Memorandum

To: Dana Sturdivant
From: Mike Nugent/Manager of Inspection Services
Date: 07/02/2004
Re: 2400 Congress St. (236 A003)

STRUCTURAL PLAN
1/4" = 1'-0"

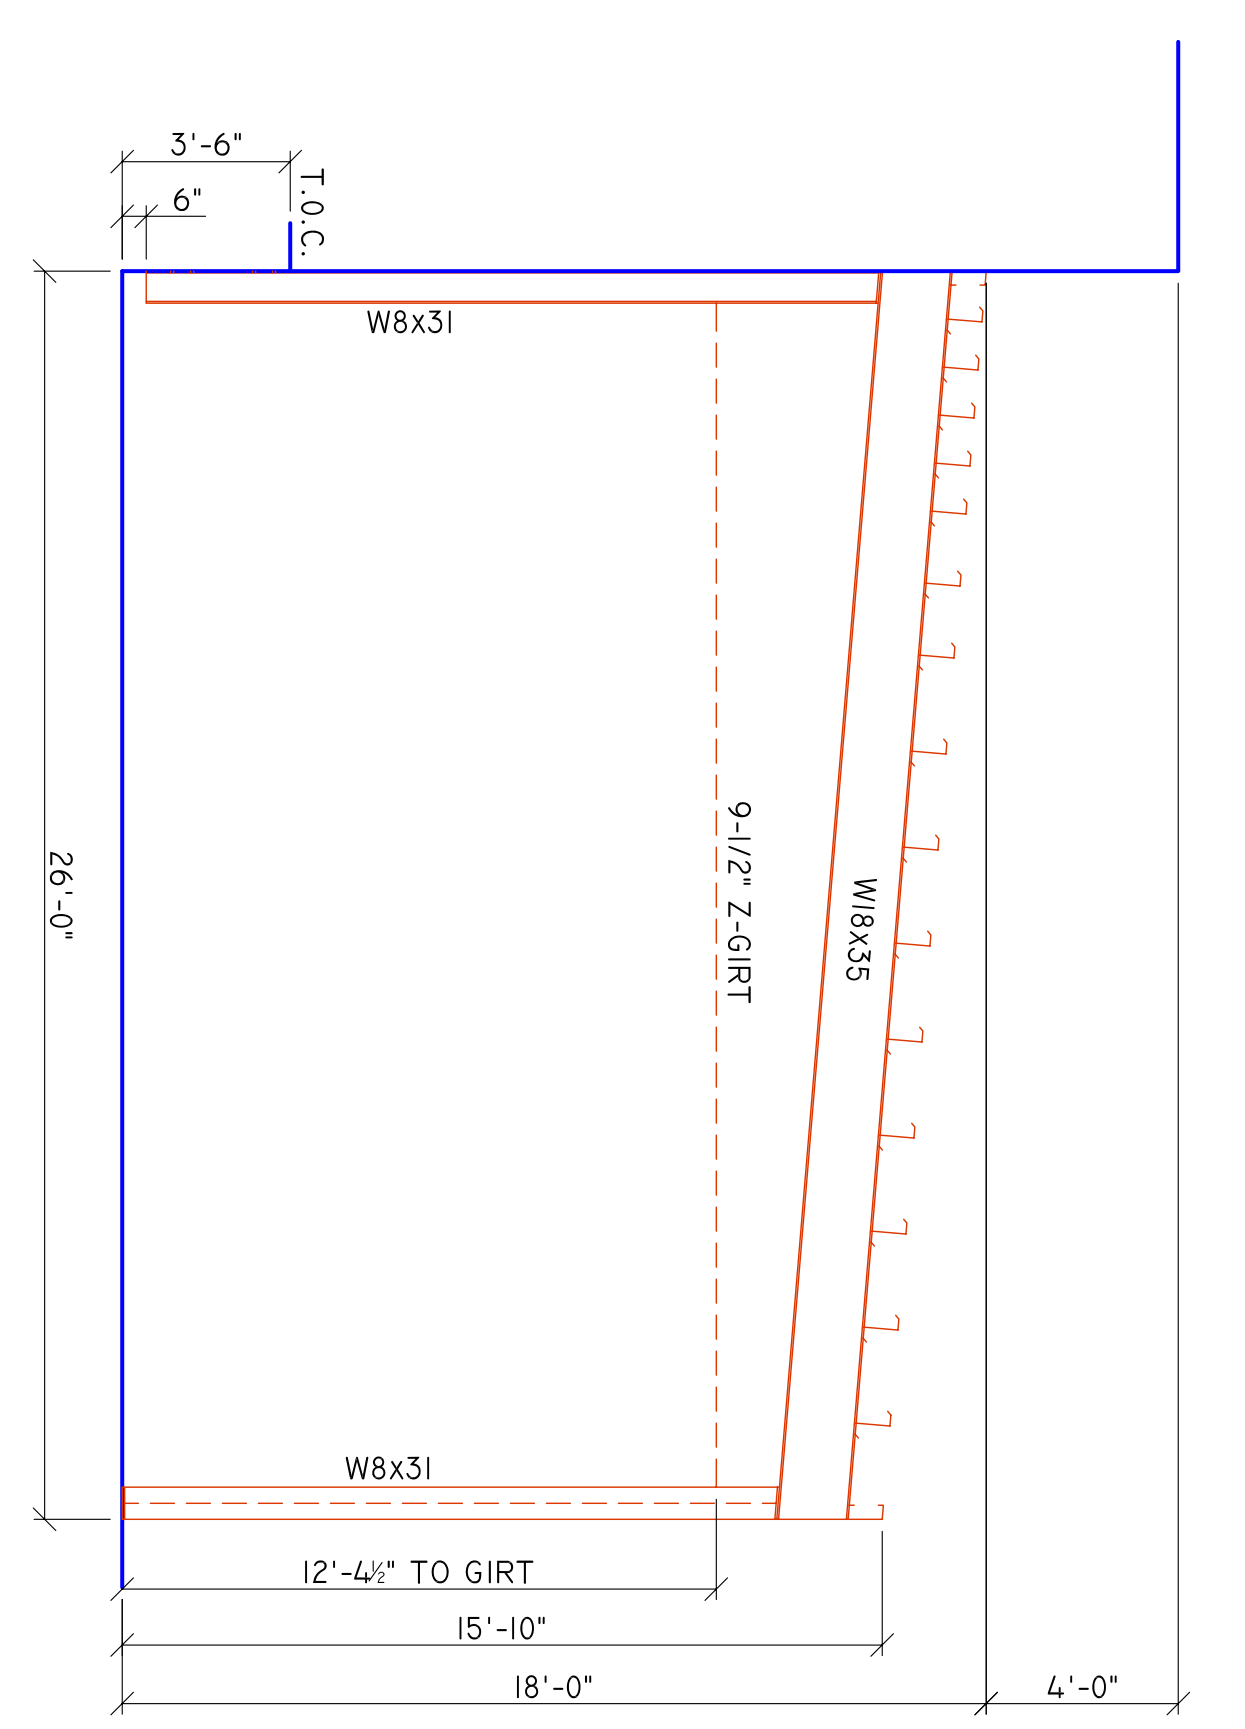
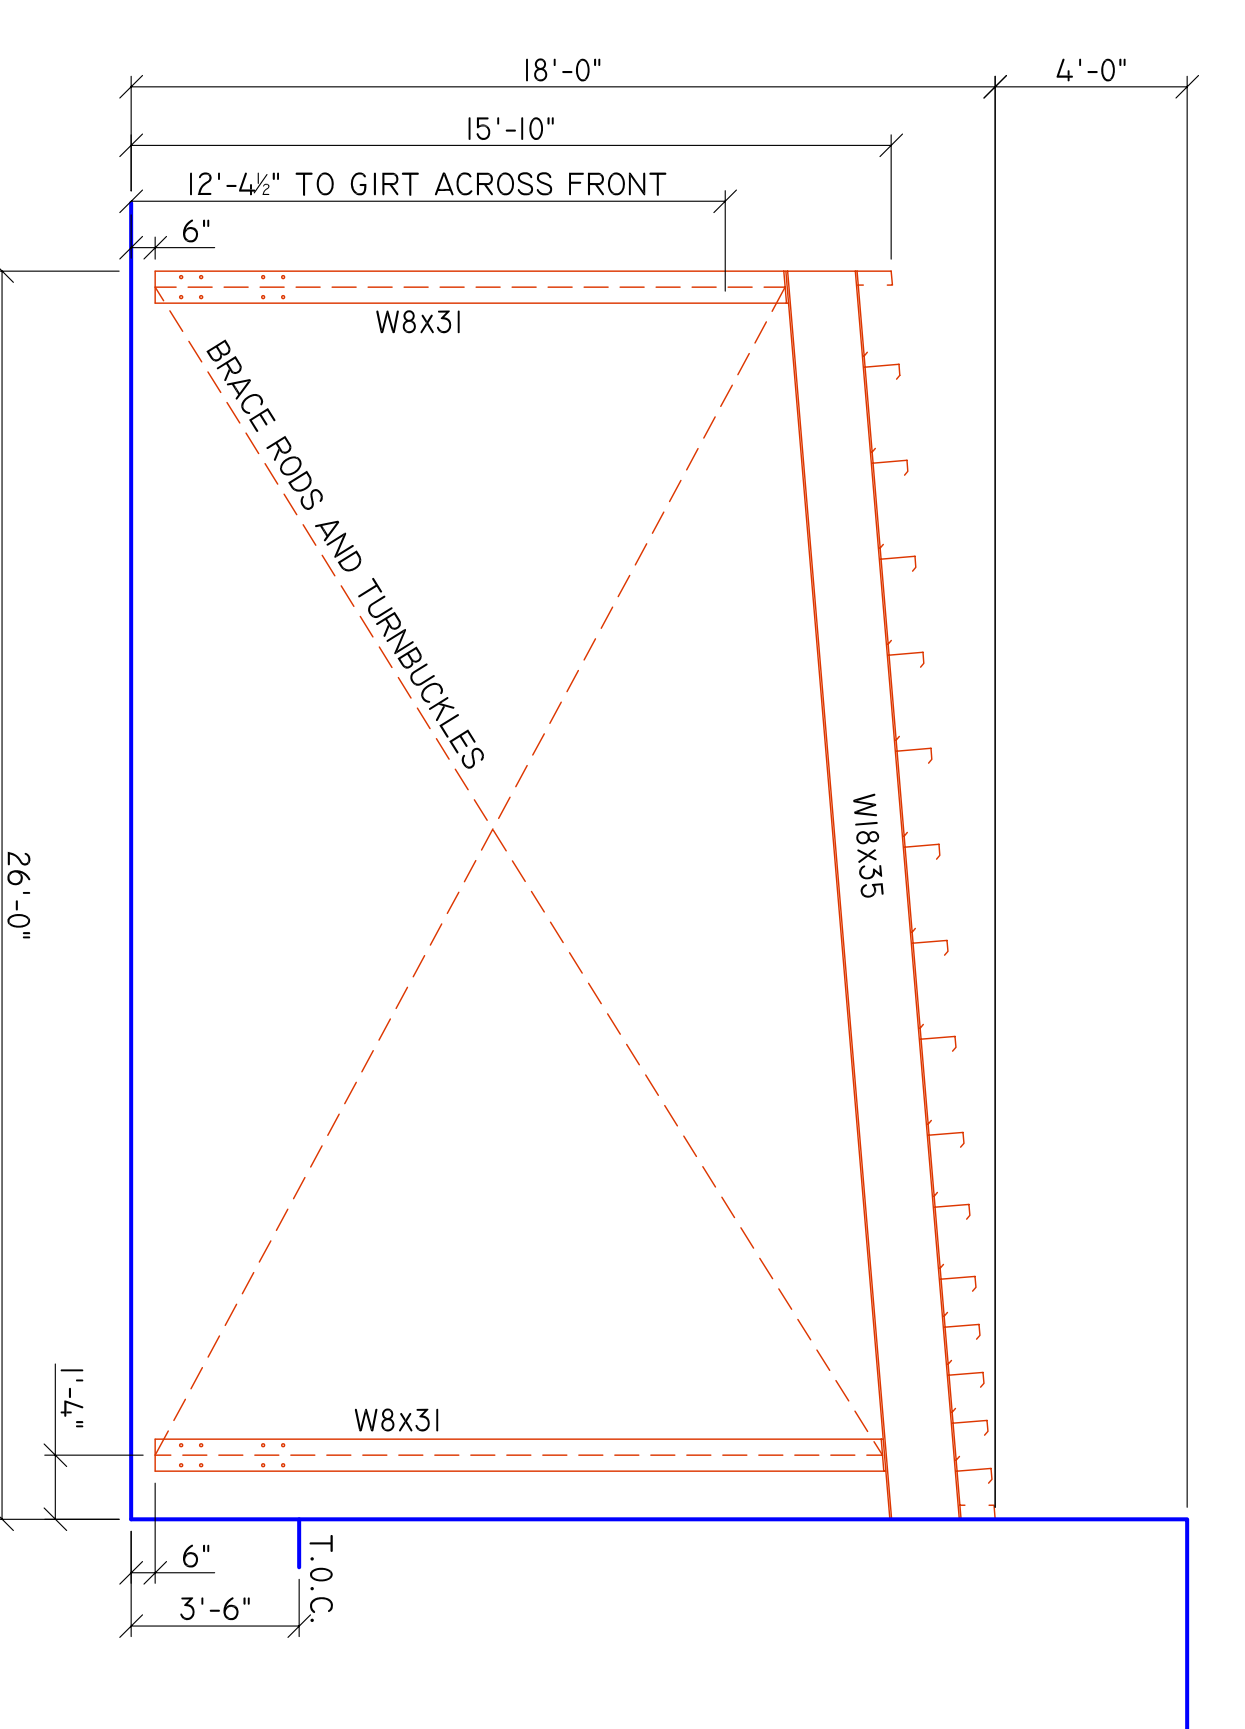
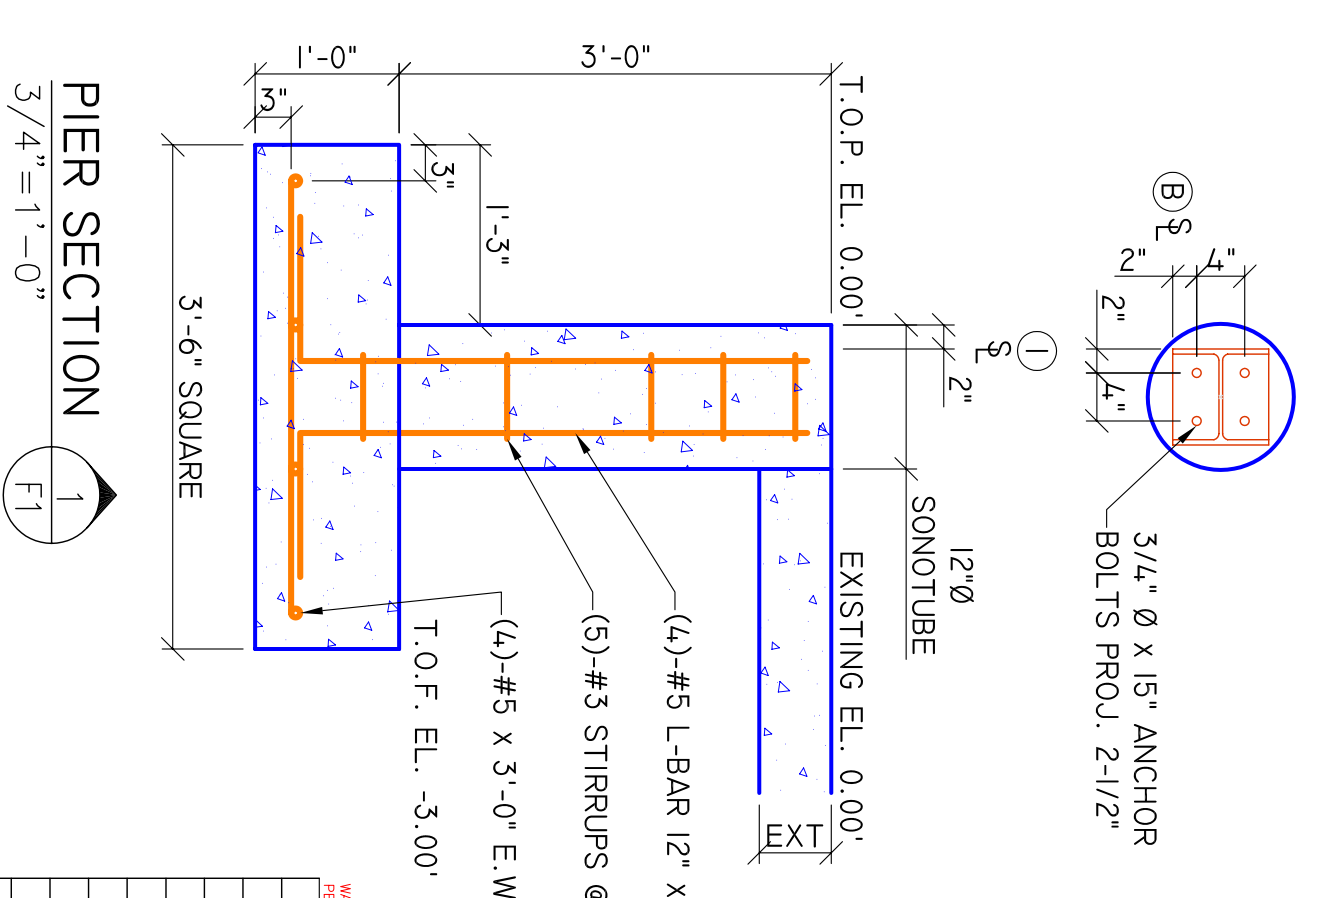
- 1) Please provide the design standard that was used in calculating the Flat Roof Snow Load.
- 2) Please provide a code justification for the omission of footings for three of the four w18 x 31 vertical supports.
- 3) Is there any structural impact on the existing structure, ie additional loads to the abutting walls?
- 4) There is no source information for the steel, nor a fastener plan, sheathing and finish schedule fore the roofing materials.
- 5) This project will require Special Inspections for the Steel and fasteners pursuant to Section 1705 of the Code.
- 6) There is a vent for an appliance of some sort shown in the photo's. Please provide a plan showing how this will be redirected and also what type of appliance it vents.
